**Planning Officer :** Damian Sullivan**Planning Application Ref:** AB/4/14/TC**Location :** Communal Courtyard, Ninevah Shipyard, Arundel**Description of works:****Himalayan Birches** – *Betula jacquemontii* x 2 of

**Reasons Given:** Prudent management and to constrain growth potential in an area between residential blocks where light percolation is a key issue**Recommendation:**

X 2 Silver Birch

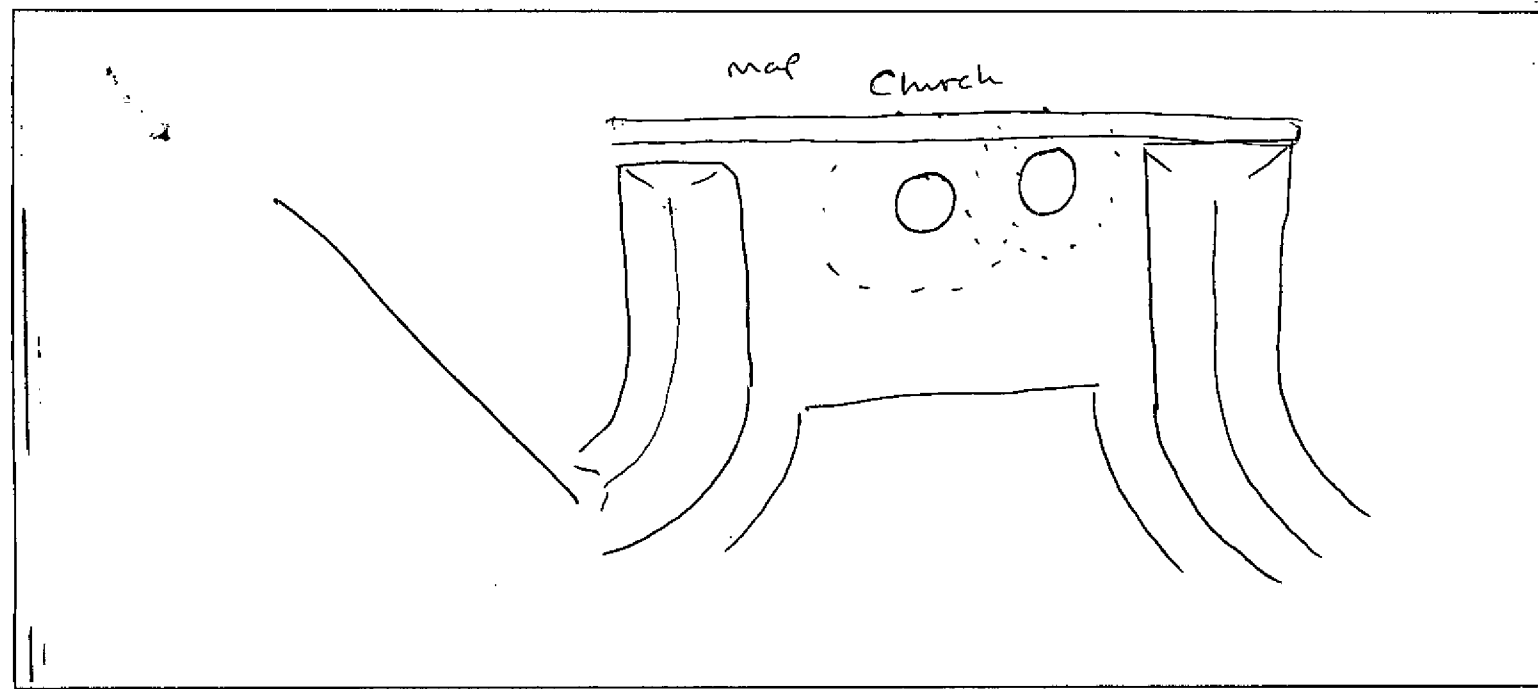
General Observation – These works are all standard maintenance operations and acceptable practice for the larger tree to the rear of the two at this location but are somewhat excessive for the front tree which is a lot smaller. This could be a problem with the current system where we now ask for reductions expressed in metres rather than percentages and they have not thought this through and applied only one measurement!

**I Approve of** the works and whilst I see no reason to apply a TPO to control them I would advise that they revert to the 20% relative to the current size and proportions of each tree rather than apply the 1.5m reduction and reshaping for both trees as they are significantly different in height and spread.

Where whole branches are to be removed final cuts close to the trunk or branch union are to be made as shown in Figure 2 of BS3998:2010 and all shortened branches are to be cut at the correct angle (see also BS3998:2010 ) and adjacent to a live bud or lateral.
